Senior Environmental Assessment Officer
Energy and Resources – Planning and Assessment
Department of Planning, Industry and Environment

Newcastle Power Station – Environmental Impact Statement

NICOLE DAVIS
A/Senior Team Leader – Planning
Hunter Central Coast Branch
Biodiversity and Conservation Division
9 December 2019

Figure 3: Known Aboriginal Heritage Sites

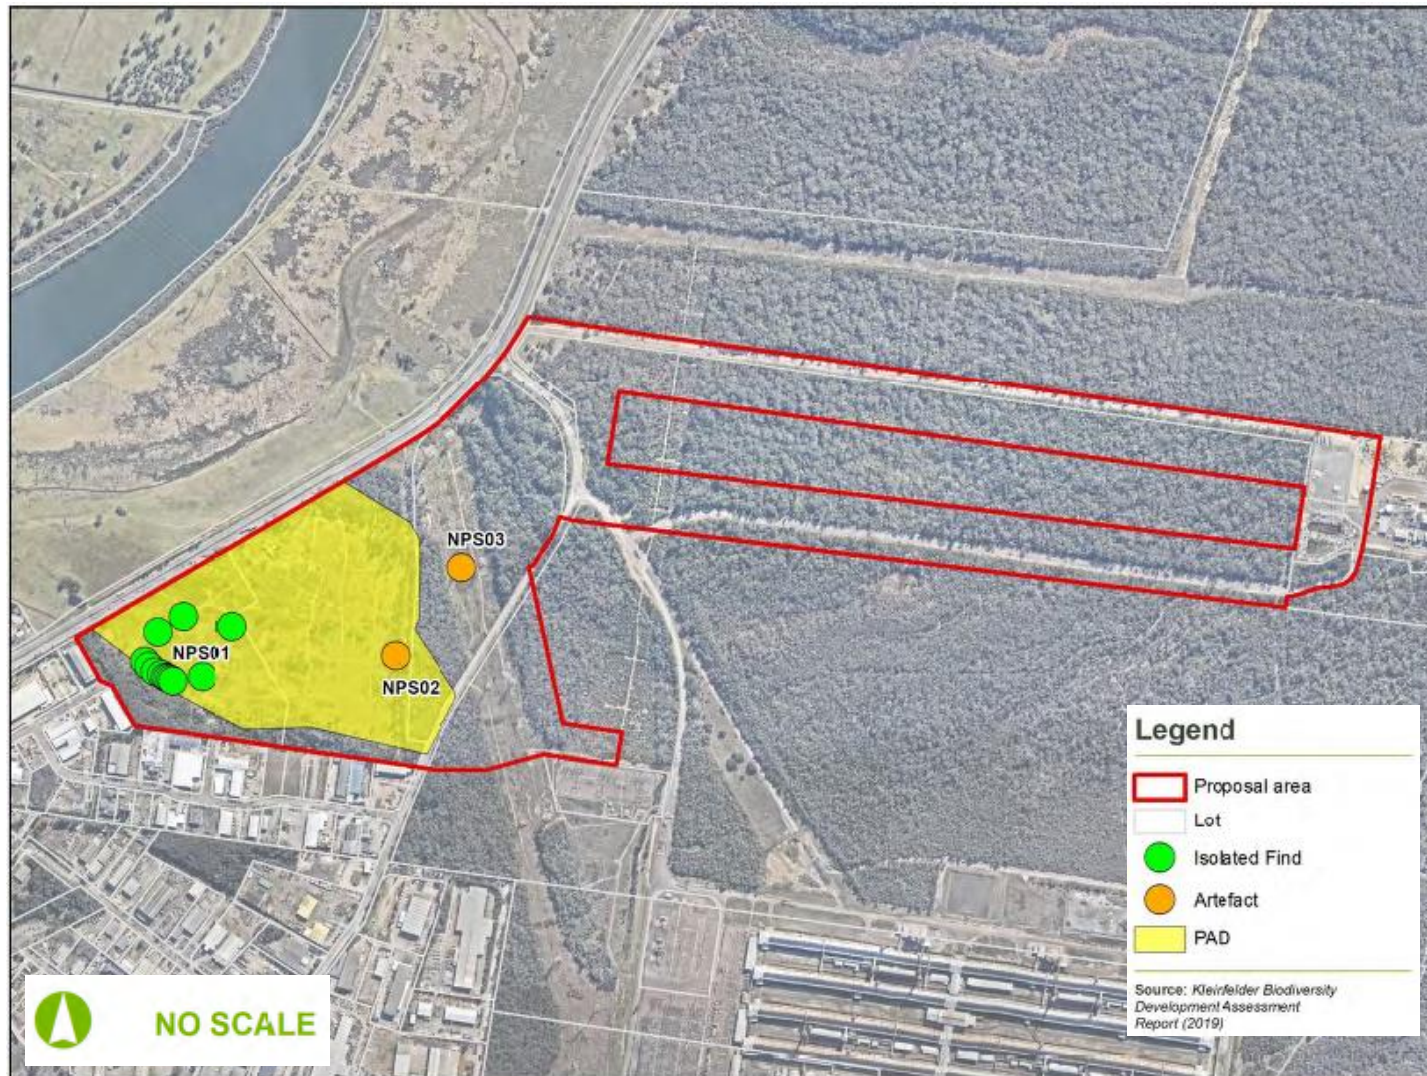
The nature and extent of the proposed activity in the vicinity of AHIMS site #38-4-2020 (NPS01) should be clarified. If the proposed activity does extend into the area where AHIMS site #38-4-2020 (NPS01) is recorded, then an impact assessment addressing the nature and extent of the proposed impact on the Aboriginal cultural heritage values of AHIMS site #38-4-2020 (NPS01) must be undertaken in consultation with the Representative Aboriginal Parties (RAPs), in accordance with Sections 2.5 of the *Guide to Investigating, Assessing and Reporting on Aboriginal cultural heritage in NSW* (OEH 2011).

BCD recommends that the ACHAR be revised to clearly identify the nature and extent of the proposed activity and its potential to impact upon Aboriginal cultural heritage values associated with AHIMS site #38-4-2020 (NPS01).
